Mark E. Jones, PE  
Structural Engineering and Design

Ref: Site Observations and Analysis  
Permit No. SFD2006-0086  
334 Kipling Rd.  
Fuquay-Varina, NC  
Project No. 22-157

The above referenced site was visited on November 9, 2022 to address the following structural condition(s):

1ST FLOOR HEADER
 2ND FLOOR FRAMING

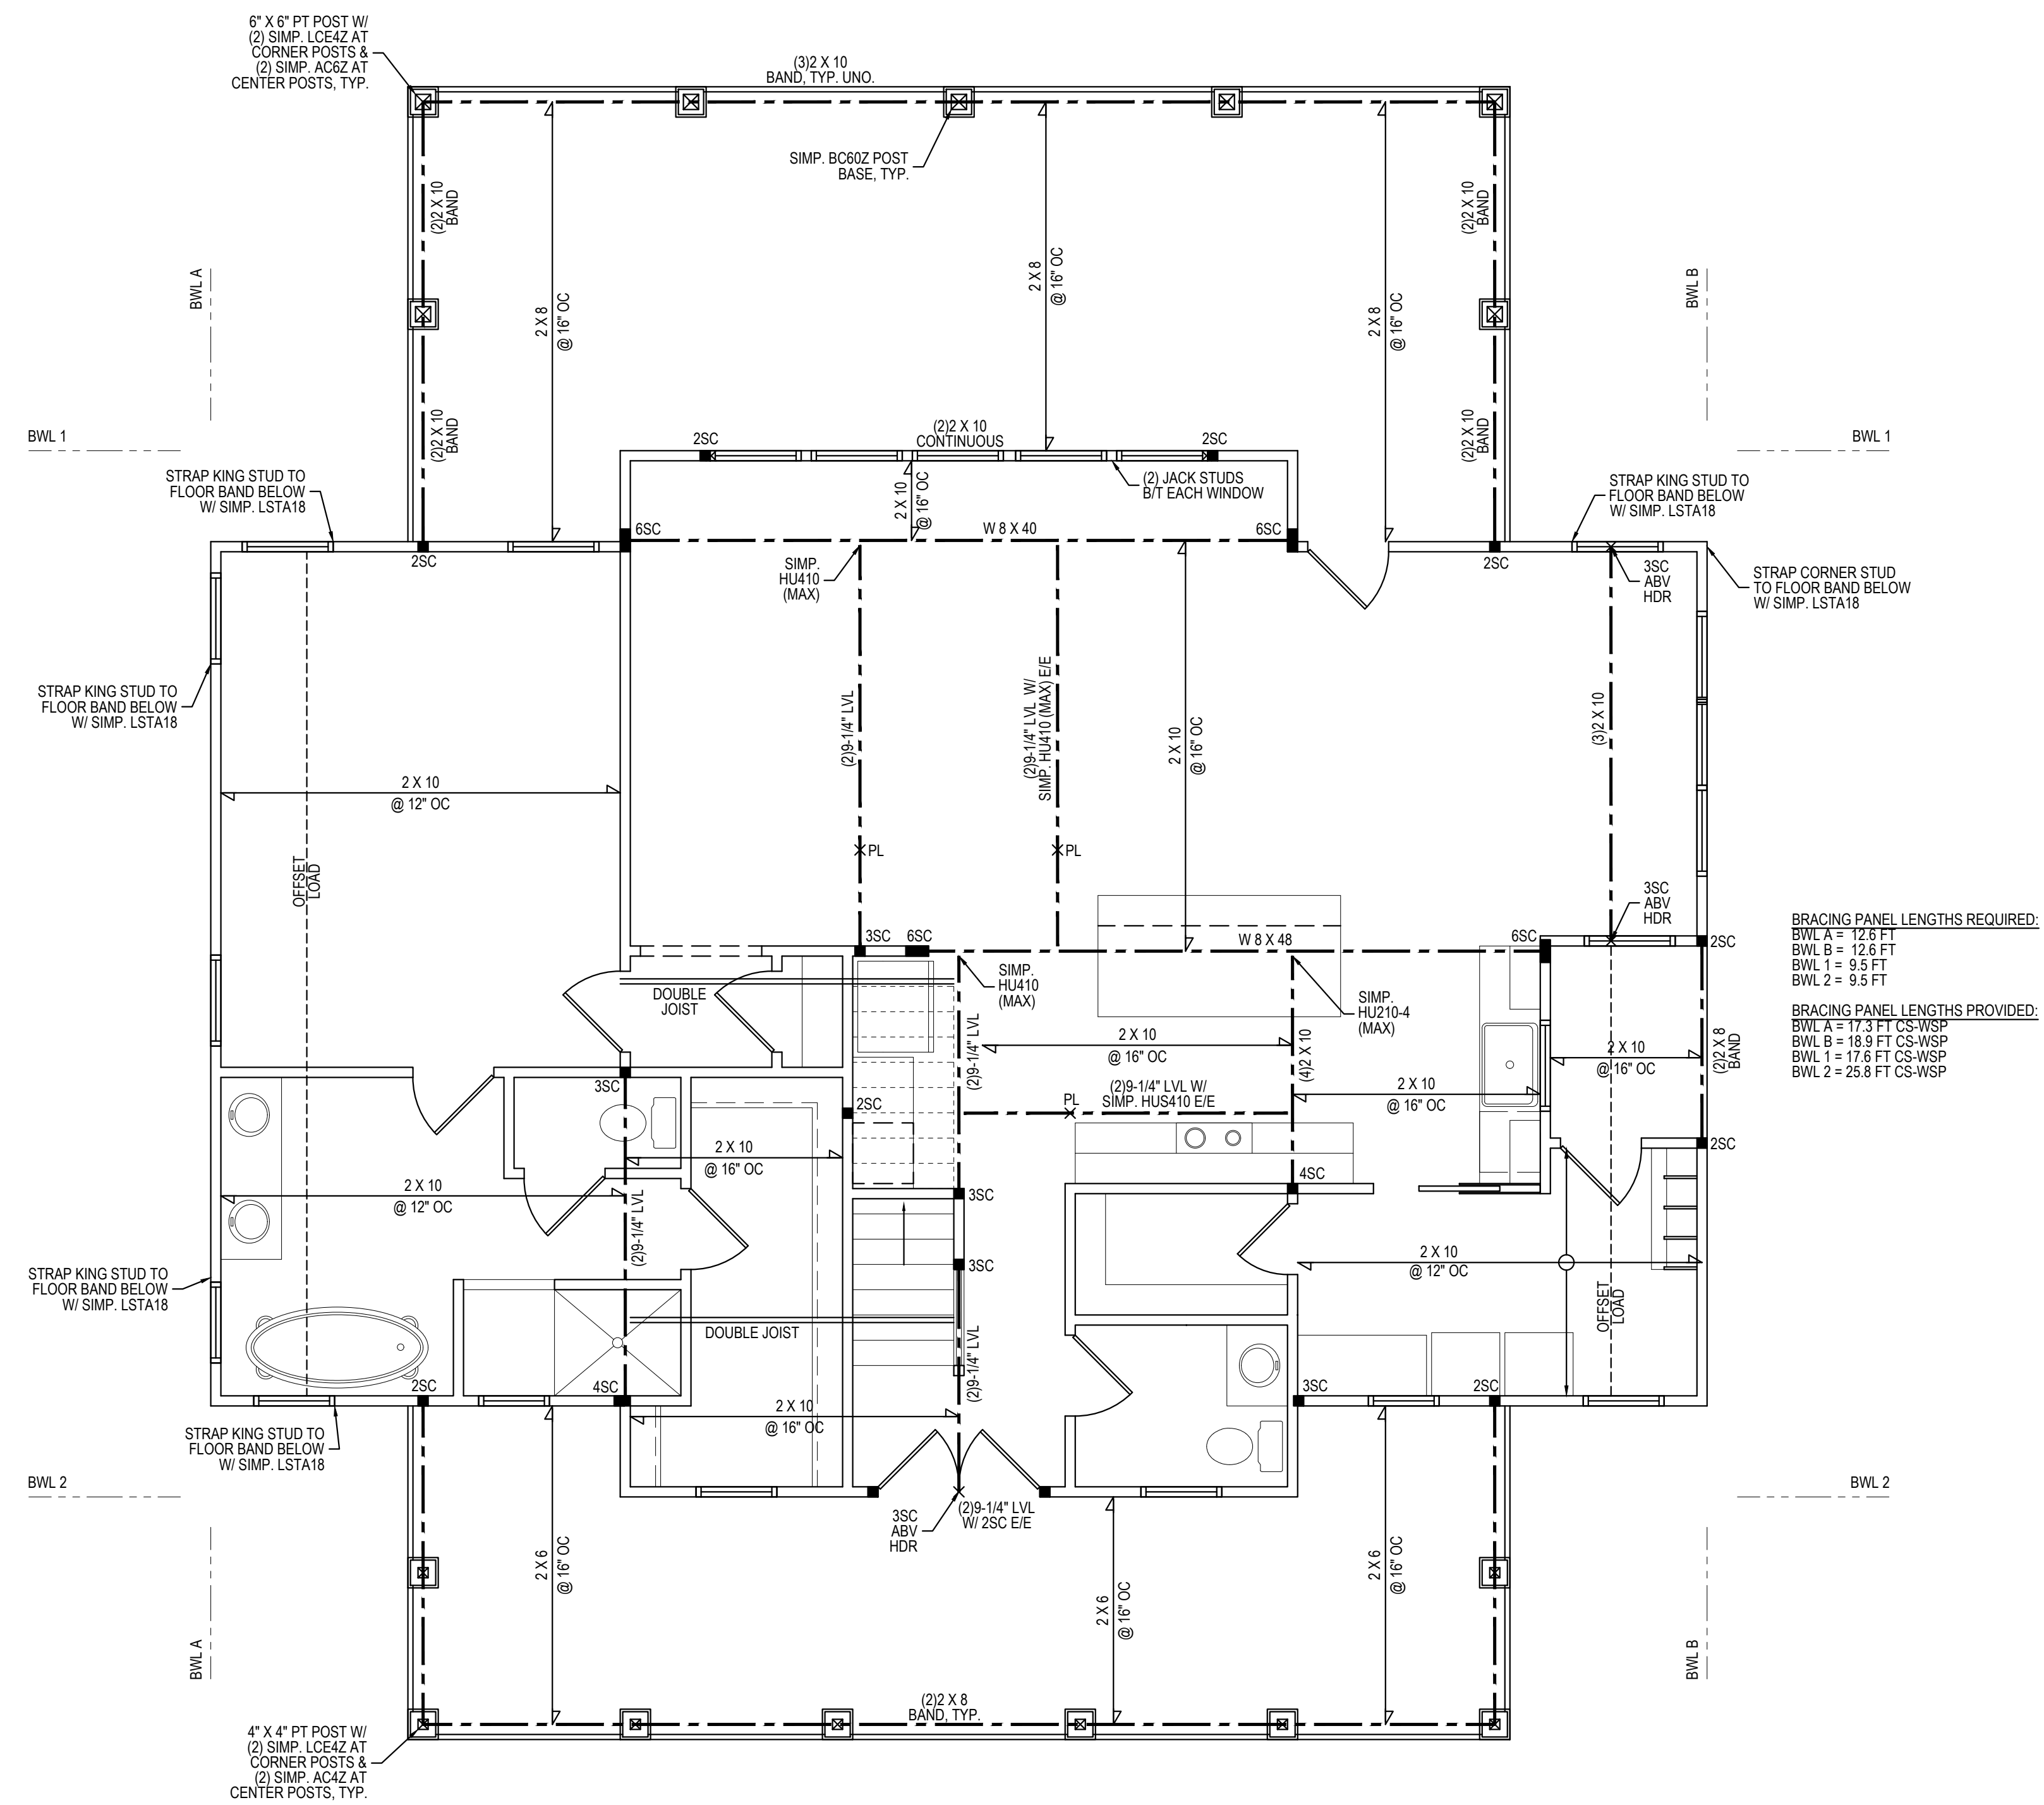
4. Valleys are 9 ¼" lvls, plans call for 11 7/8".
5. Steel beam full bearing on flange at foyer.

4. Upon detailed analysis of actual spans and loading conditions, the existing (2) 9 ¼" LVL valley beams are adequate to support all imposed design loads. No repair or enhancement is required.
5. The W8x48 steel beam (flange width 8 1/8") bearing on (6) 2x4 studs (3 ½" width x 9" long) per plan is adequate to support all imposed design loads. No action is required.
